Application H02-0578-19
Location Land at Harvester Way Crowland
Proposal Details of affordable housing - revised boundary treatment, external materials, surface water drainage, construction management and wheel washing facilities (Conditions 3, 4, 5, 7, 8 and 9 of H02-0062-19)

Name Angela Doherty
Address Housing Strategy

Date Submitted 12-07-19
For/Against Comments

17239/1007C

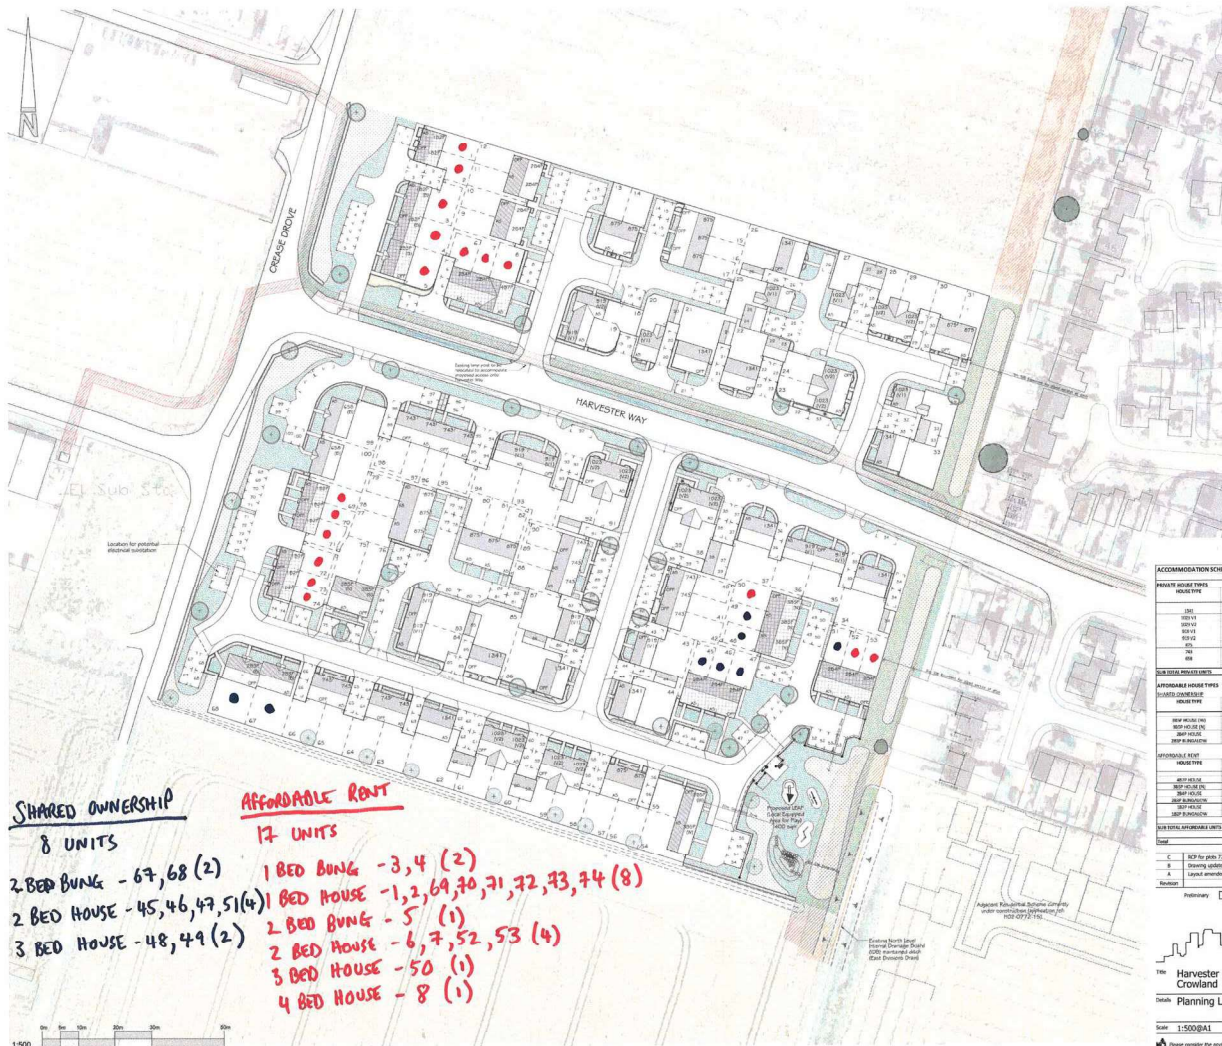
From reviewing plan 17239/1007C of this condition compliance application the applicant is proposing 25 affordable homes, comprising of the following:

17 for Affordable Rent- 2 x 1 bed bungalows (plots 1 & 2), 8 x 1 bed houses (plots 1,2,69,70,71,72,73 & 74), 1 x 2 bed bungalow (plot 5), 5 x 2 bed houses (plots 6,7,51,52,& 53) and 1 x 4 bed house (plot 8) and

8 for Shared Ownership- 2 x 2 bed bungalows (plots 67 & 68), 3 x 2 bed houses (45,46 & 47) and 3 x 3 bed houses (plots 48,49 & 50).

This mix differs from the suggested mix identified on 1 February 2019 as part of the condition compliance application H02-0062-19. As per my previous comments and supported by Policies 17 and 18 in the Local Plan it would be preferable for the applicant to amend the plans to deliver that mix, comprising of:

18 for Affordable Rent- 6 x 1 bed houses, 8 x 2 bed houses and 4 x 3 bed houses and

7 for Shared Ownership- 2 x 2 bed bungalows, 2 x 2 bed houses and 3 x 3 bed houses.

It would be preferable for the homes to be built to the 'Nationally Described Space Standards'. Ideally the affordable housing should be spread proportionately across the scheme to enable a mixed and sustainable community. The applicant has sought to achieve this by mixing the 25 affordable homes across three parcels of the scheme in plots 1-8, 45-53 and 67-74.
